WA/32/21/PL

Please register this as an objection to the above planning application and upload this letter and WSCC Flood pages to the planning portal.

Client: Macra Ltd
 DRWG No: **P20-2233_06** Sheet No: _ REV: B
 Drawn by : TH Approved by: TH
 Date: 31/03/2021
 Scale: 1:1,250 @ A3

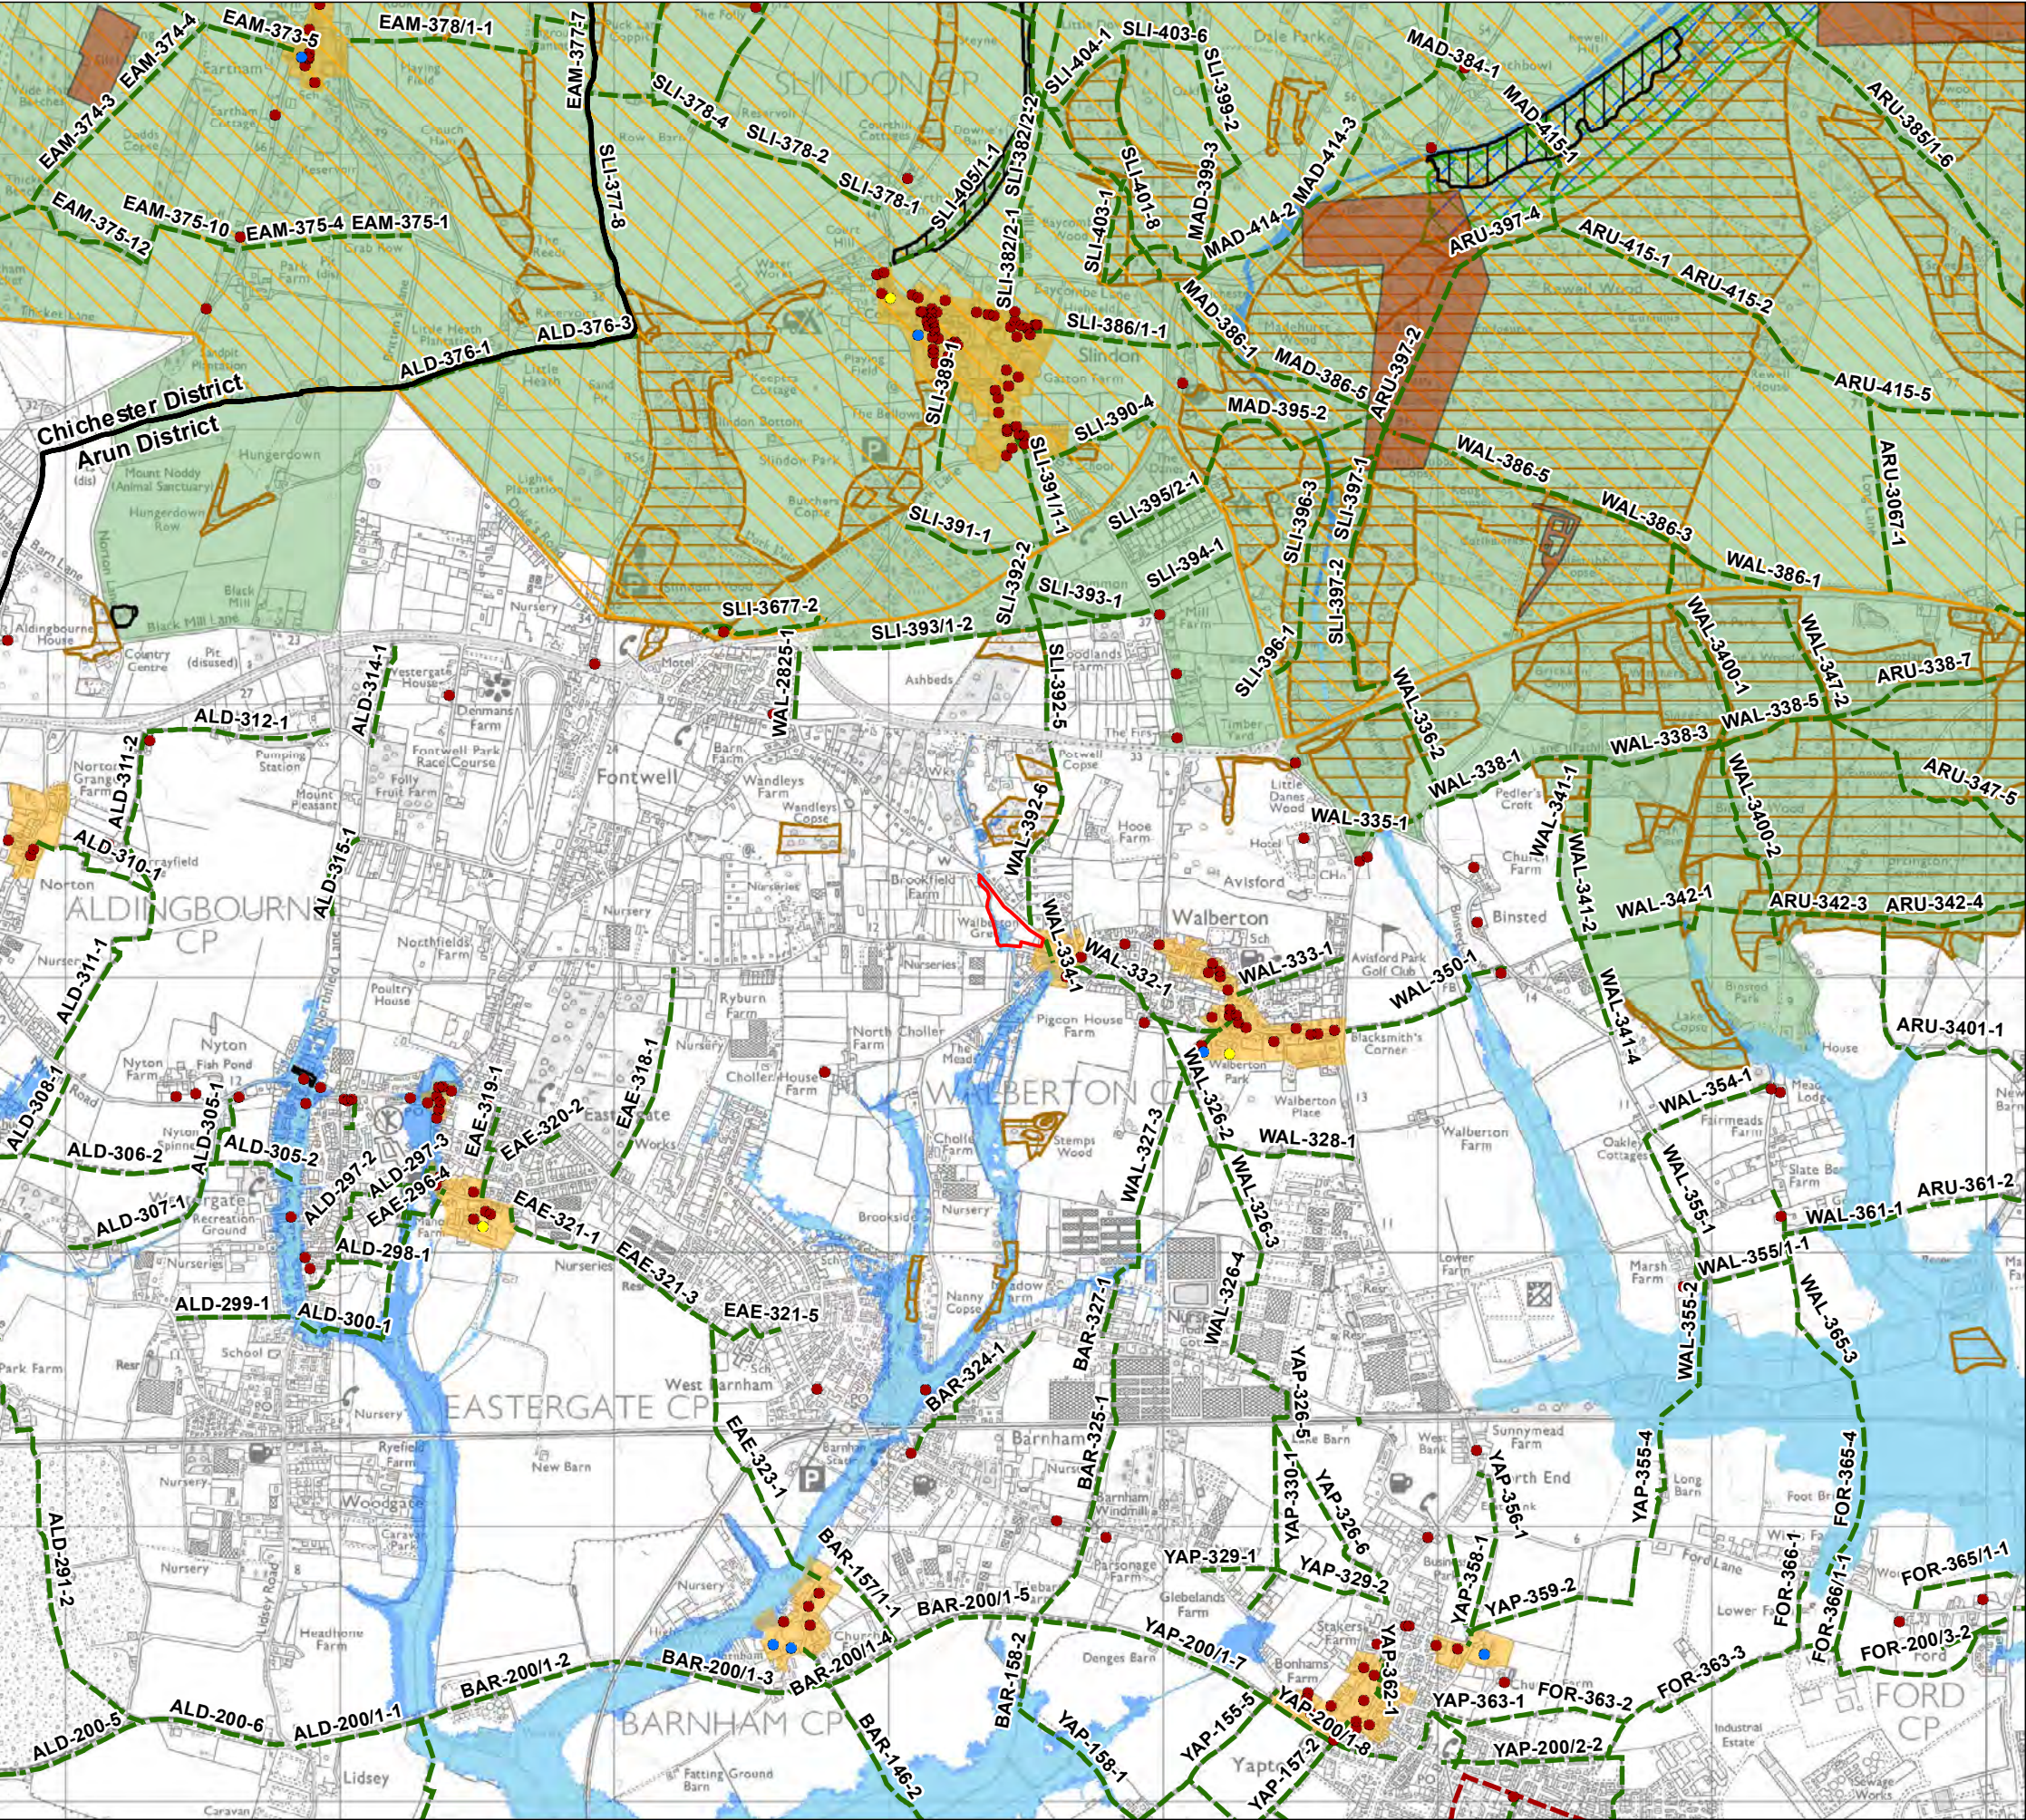
Walberton Parish Council would need to give permission to open access from the site on to The Green and to our knowledge has not been approached.
